30th June 2021

Town & Country Planning Act 1990 (as amended)
Town & Country Planning (Development Management Procedure) (England) Order 2015

Application No: Y/84/21/HH
Site Address: 5 Hobbs Court, The Potting Barn Bilsham Road Yapton BN18 0JY
Description of works: Installation of 1.8m timber fence and gate and infill of existing dummy door and panelling under window

PROJECT	THE POTTING BARN HOBBS COURT, BILSHAM ROAD YAPTON BN18 0JY		
DRAWING	HOUSE PLAN PROPOSED BOARDERED FENCE		
Date	June 2021	Drawn By	PJC
Scale	1: 100 @A3	Iss. App. By	DKC
Drawing No	023 A	File Location	0221

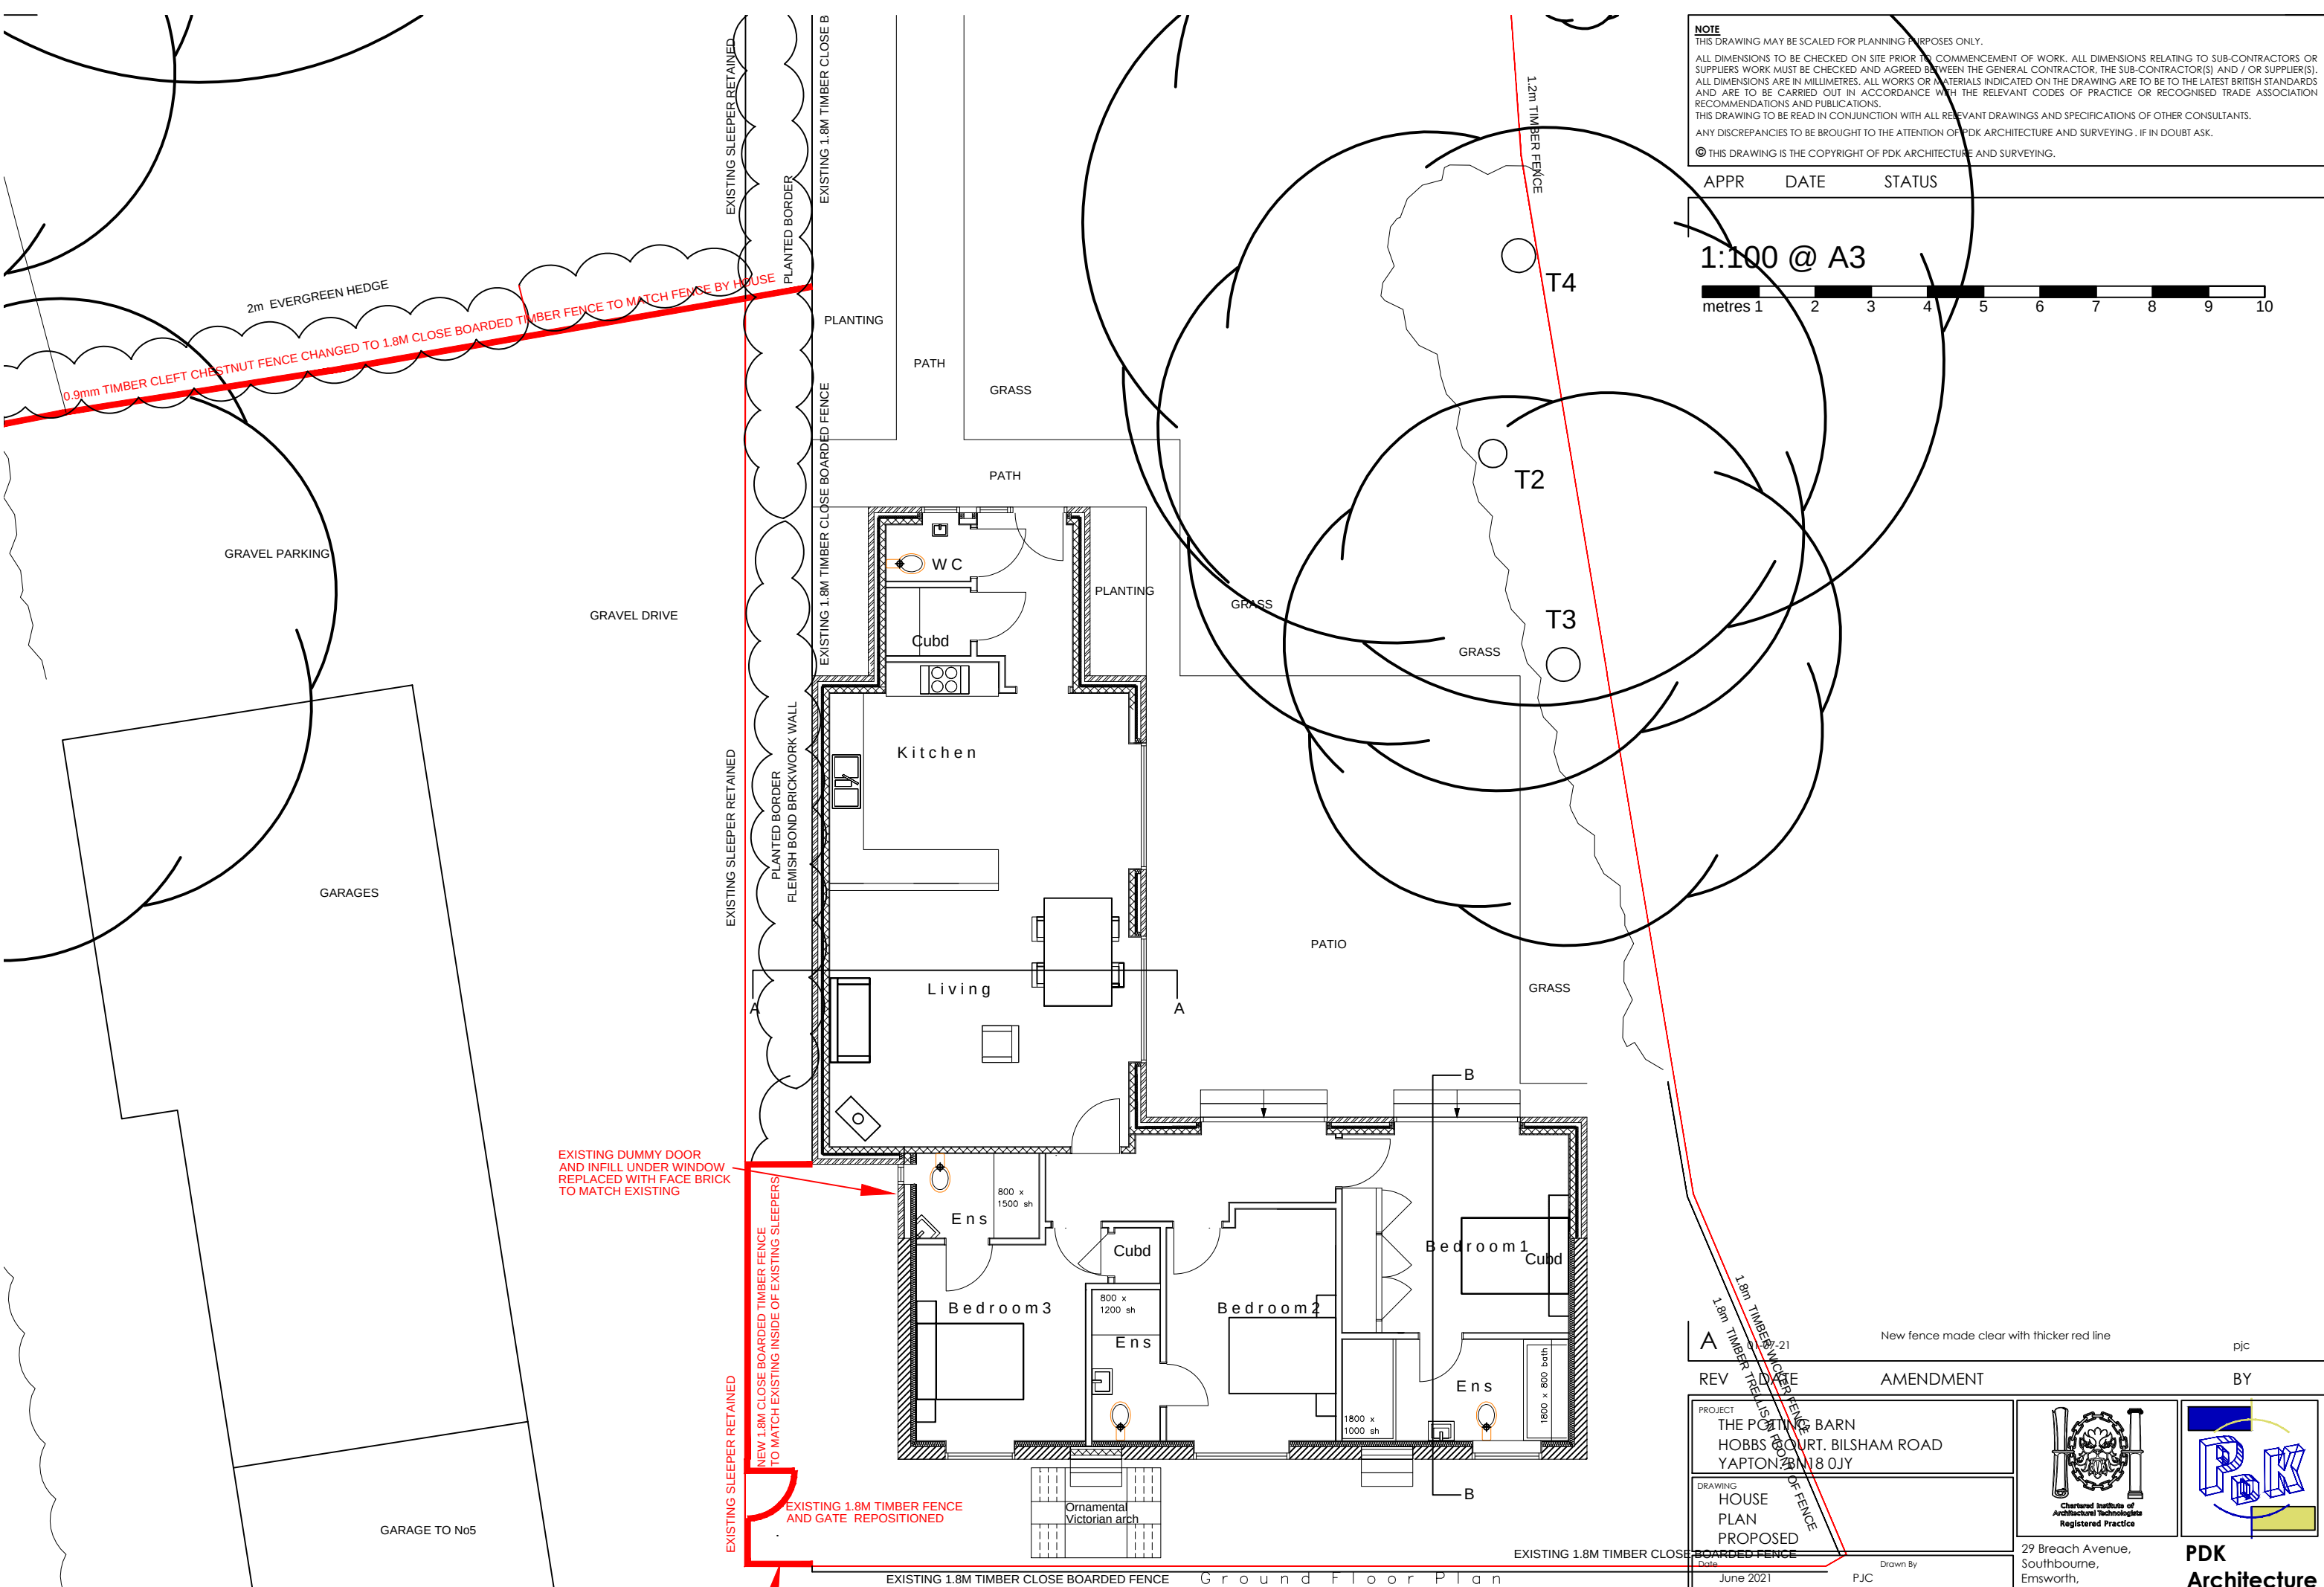
This is not an objection to fencing per se but the drawing suggests new fencing is being erected on the South West elevation of the property, which is in fact my existing fencing and my responsibility. Please could you clarify that the drawing should in fact state that the fencing is to be erected on the West elevation (not South West). A plan view of the site would make it clearer to neighbours.
